Our ref: RA/2023/145899/04-L01
Your ref: 2023/91441

Date: 01 May 2025

CHANGE OF USE AND ALTERATIONS TO FORMER CHURCH (B8-STORAGE) TO 9 RESIDENTIAL UNITS (C3) AND FORMATION OF CAR PARK (LISTED BUILDING WITHIN A CONSERVATION AREA) – 31 CHAPEL HILL, LINTHWAITE, HUDDERSFIELD, HD7 5NJ

Environment Agency position

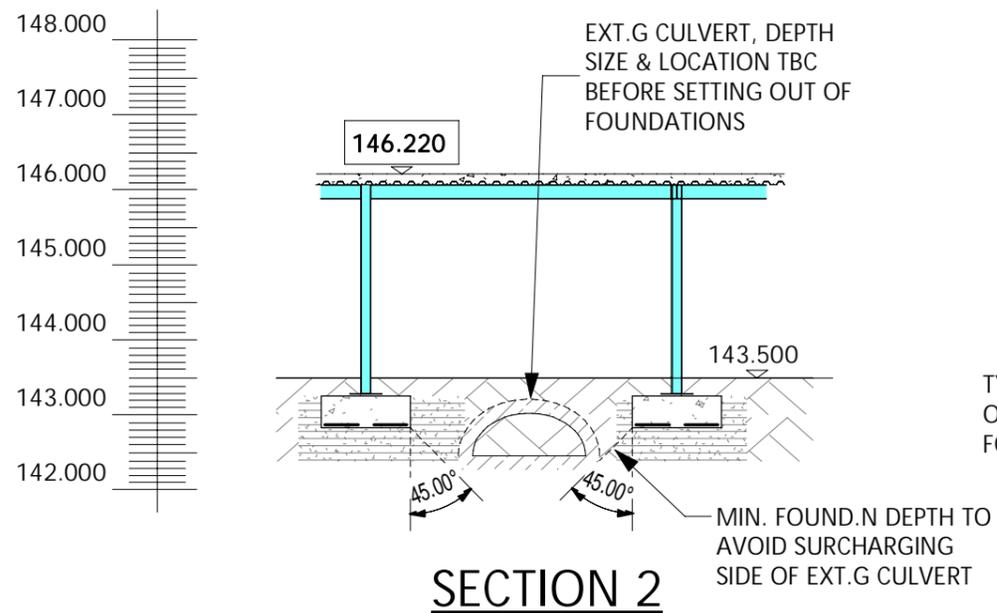
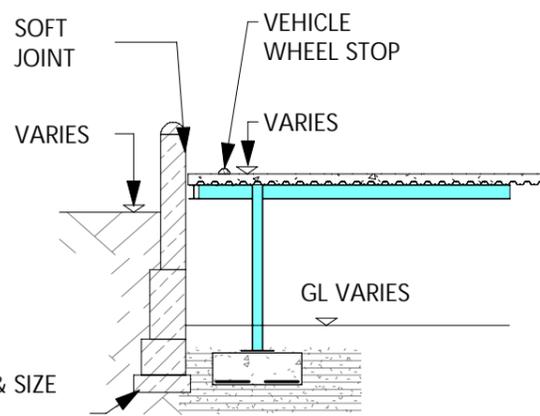
The applicant must provide evidence of the precise culvert location instead of an approximation to demonstrate that the proposals will not compromise the structural integrity of the culvert structure and its function.

We note that the proposed cross section drawing appears to contrast with the Decked Car Park plan drawing. The latter suggests a structure is proposed over the assumed culvert position. The applicant must provide evidence that the proposal will not impose additional loading on the culvert structure once its precise location has been established. Alternatively, if this cannot be achieved, the applicant must demonstrate and evidence that any loading imposed by the development on the culvert can be withstood by the culvert for us to find the proposals acceptable.
